Application by Rosefield Energyfarm Limited for an order granting development consent for the Rosefield Solar Farm

The Examining Authority's (ExA) schedule of proposed changes to the applicant's draft Development Consent Order (dDCO) (Revision 07) [REP4-006]

Issued on: 15 July 2026

LEGEND:

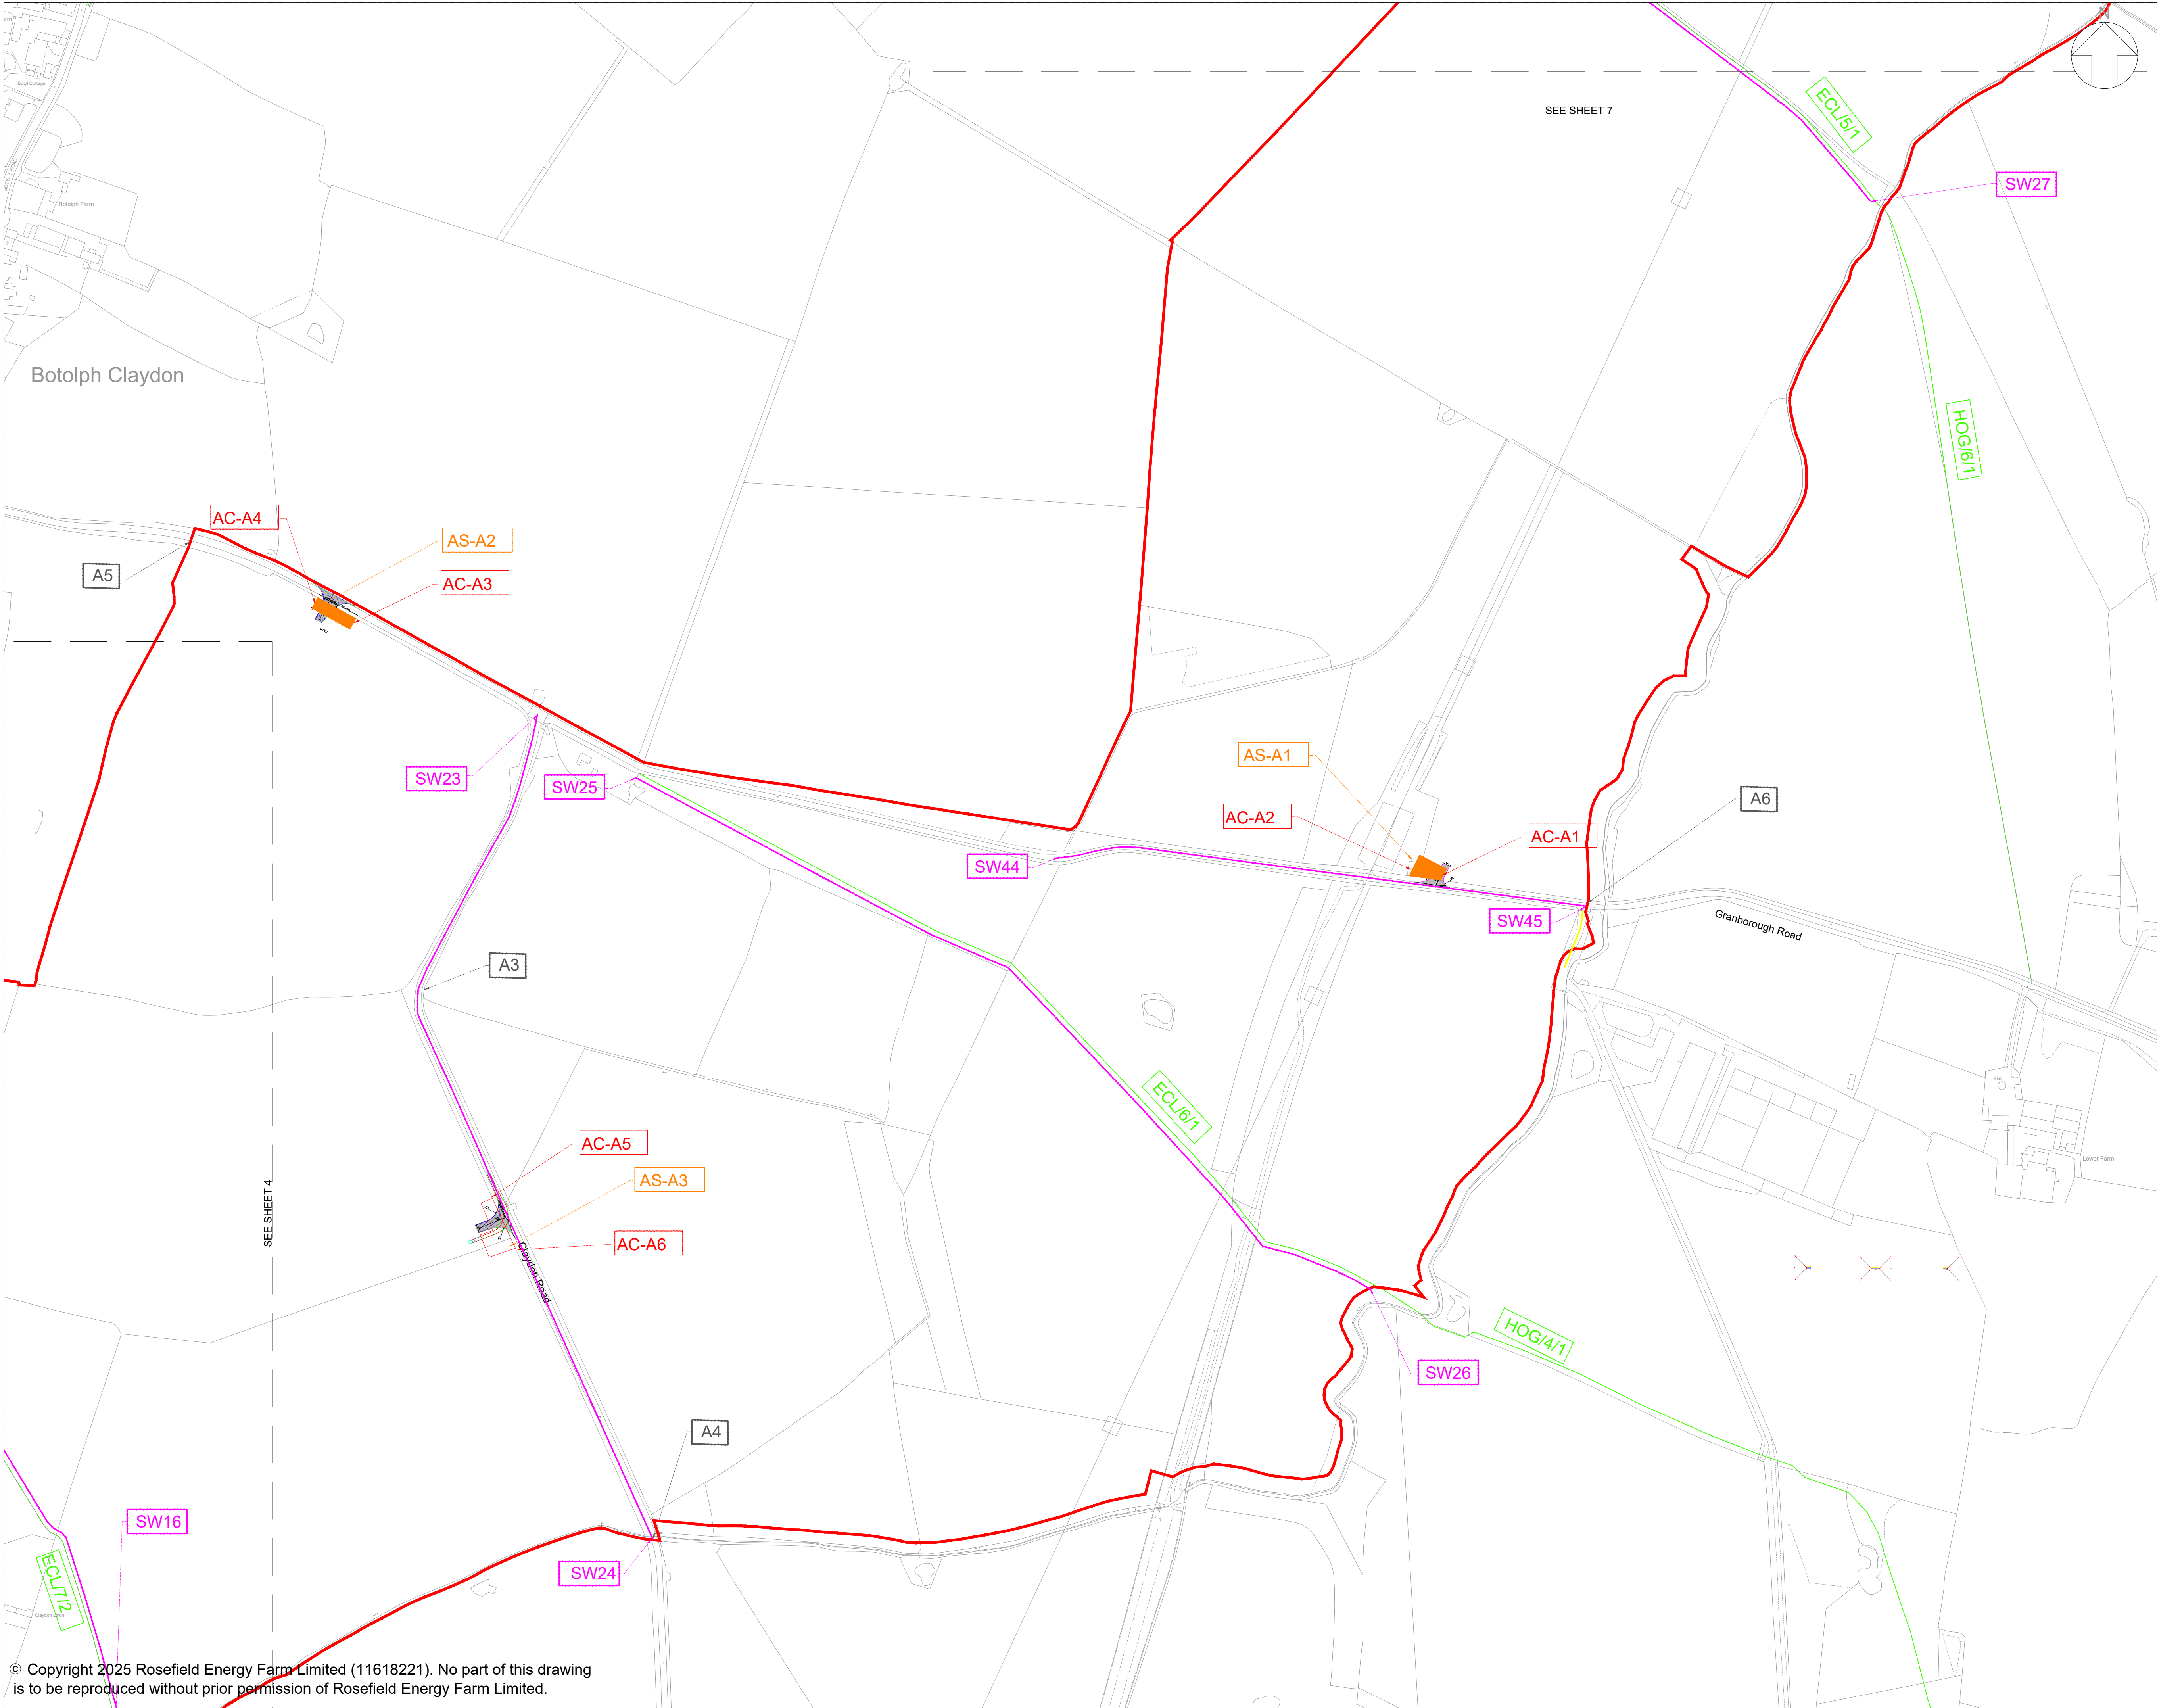
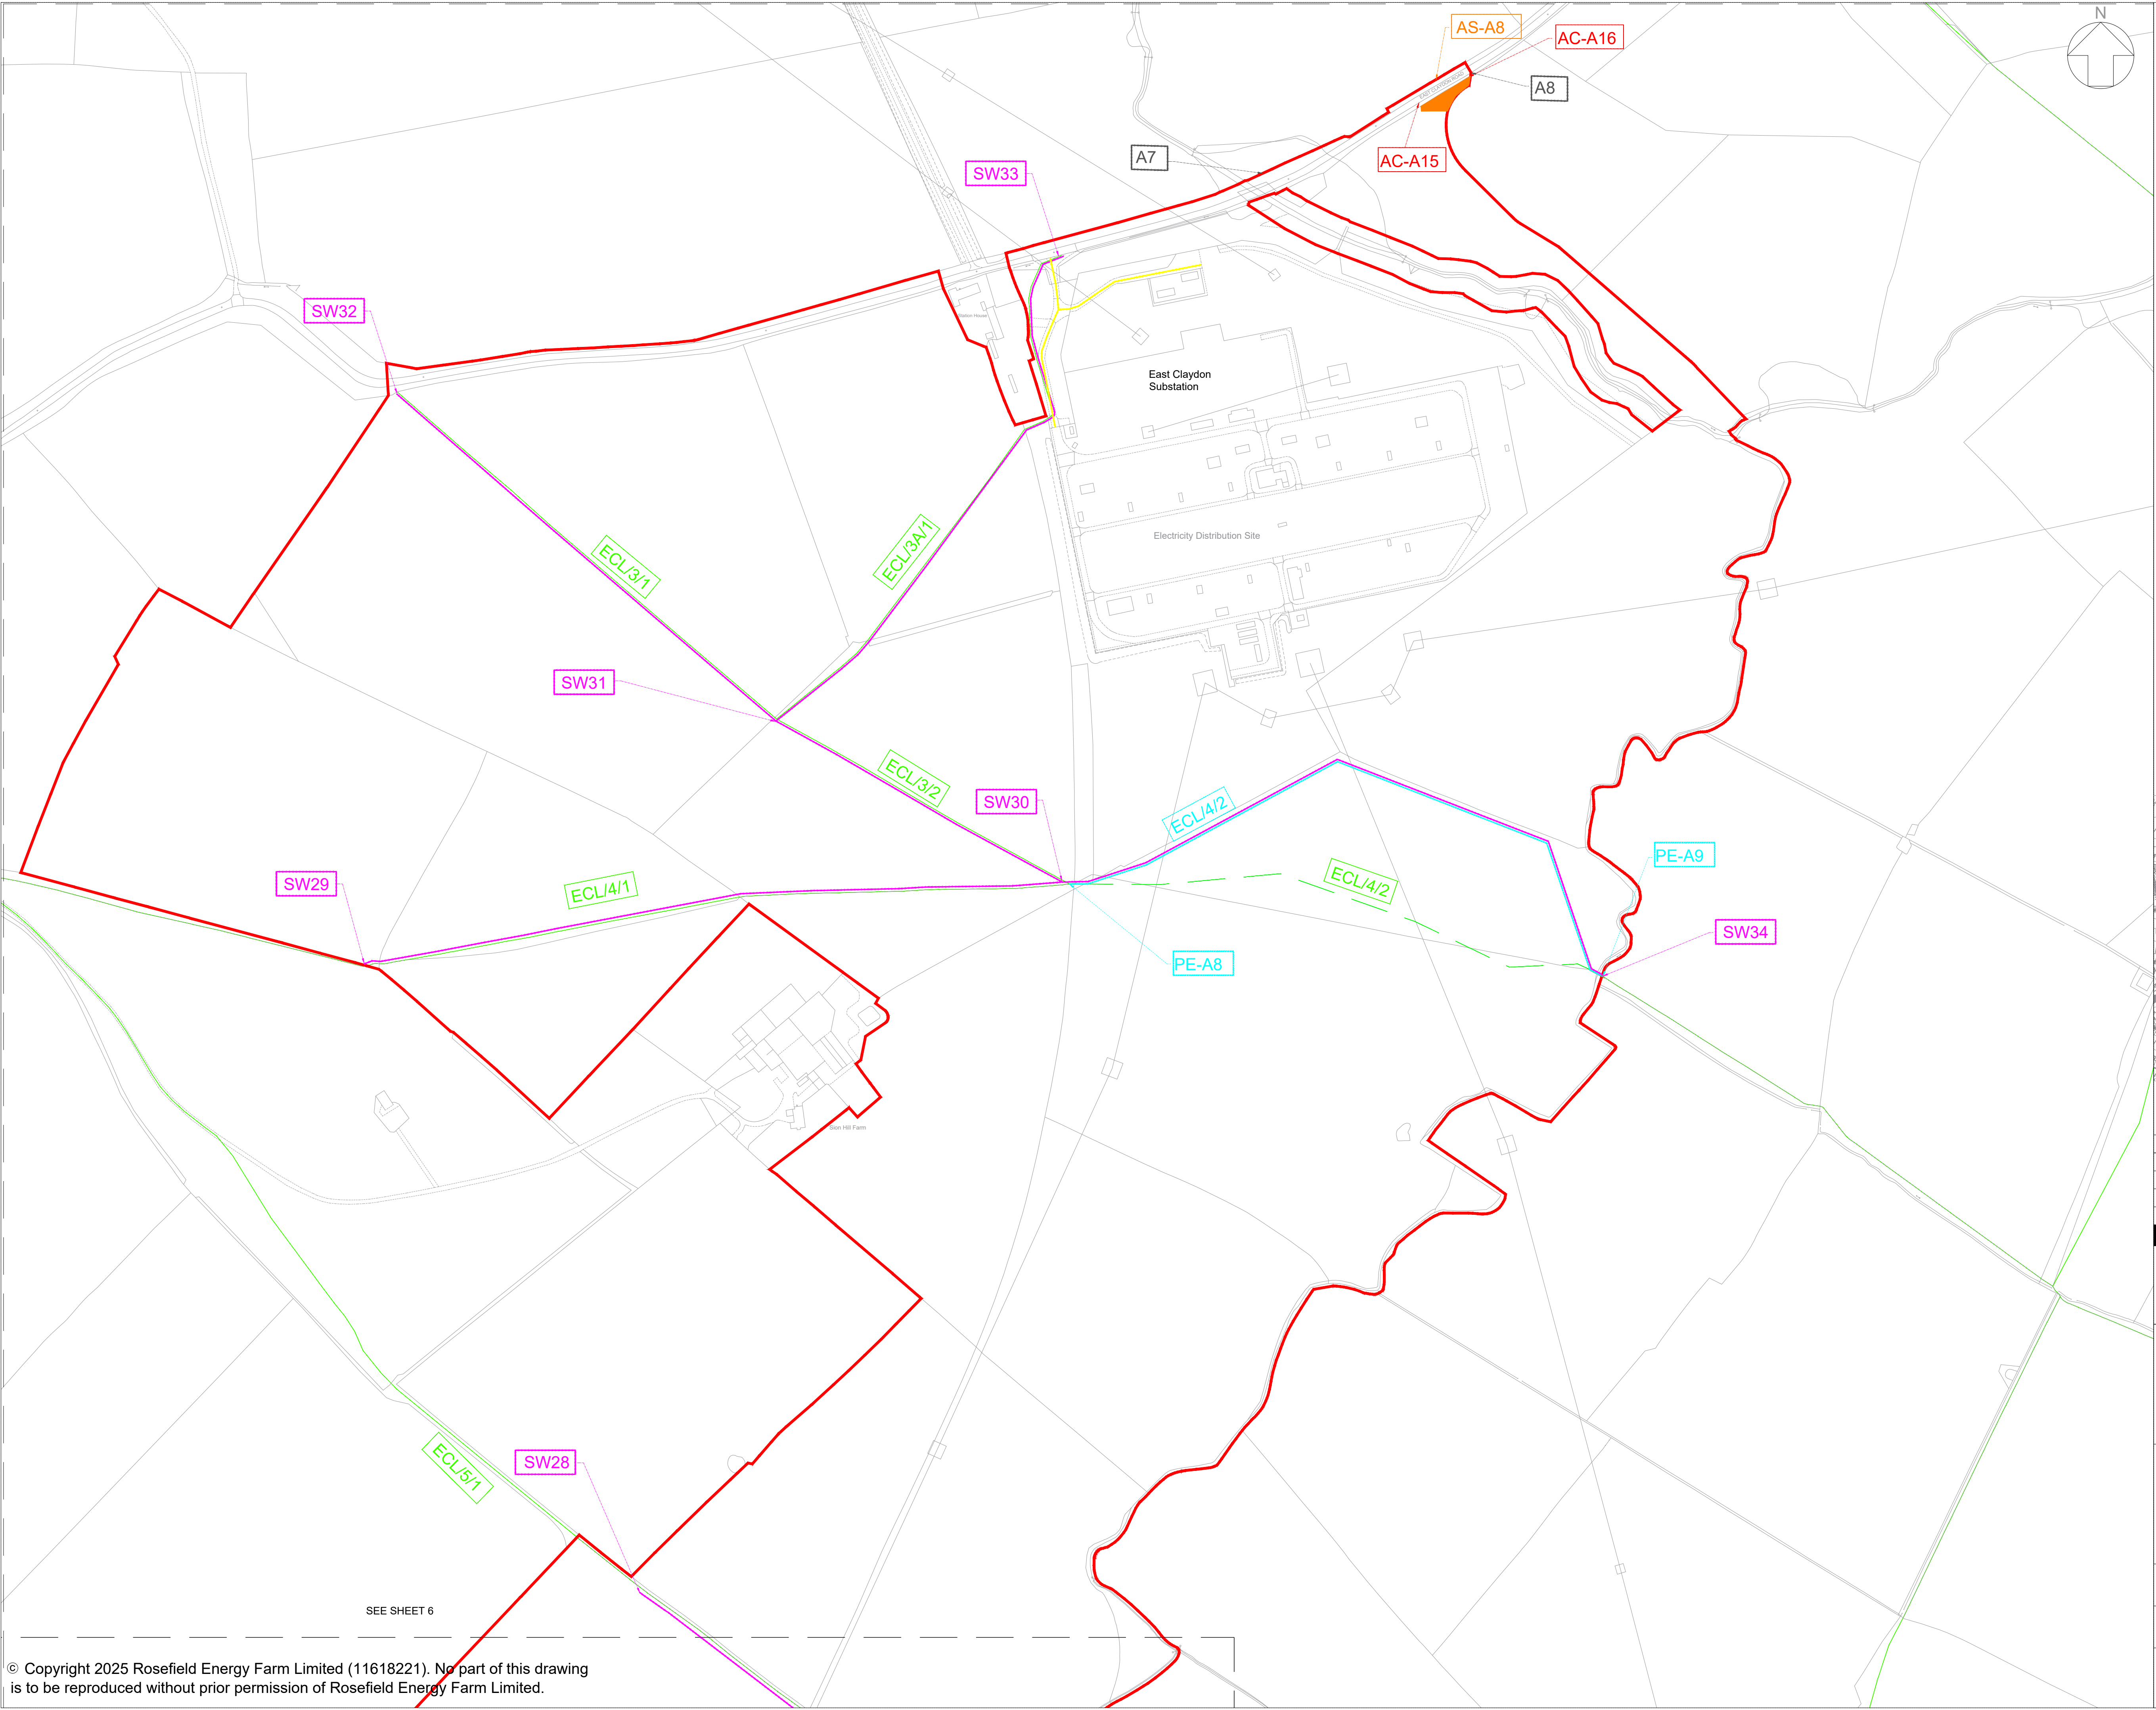
Article/ Schedule	ExA's proposed changes Deletions shown as strike through (for example) Insertions shown in bold (for example)	ExA's reasoning and comments
		However, the ExA considers this should be expressly stated in the dDCO.
Article 12 – Temporary prohibition or restriction on the use of streets and public rights of way	(10) The undertaker must restore any public right of way that has been temporarily altered under this Order to the reasonable satisfaction of the street authority	This provision would be the equivalent to the obligation contained at Article 10(2) and the ExA considers it is required to ensure a proper reinstatement of public rights of way.
Article 14 – Use of private roads	(1) The undertaker may use any the private roads specified in (2) For the purposes of section 9 (requirement of licence for felling) of the Forestry Act 1967(b) any felling comprised in the carrying out of any work or operation required for the purposes of, or in connection with, the construction of the authorised development is deemed to be immediately required for the purpose of carrying out Schedule “X” within the Order limits for the passage of persons or vehicles (with or without materials, plant and machinery) for the purposes of, or in connection with, the construction or maintenance of the authorised development.	The ExA considers that this proposed power is too broad and for clarity needs to be restricted to those private streets that the applicant intends to use for the proposed development. The update to the Streets, Rights of Way and Access Plans at deadline 4 [REP4-005] does not provide this clarity, only showing the location of all private streets within the order limits.
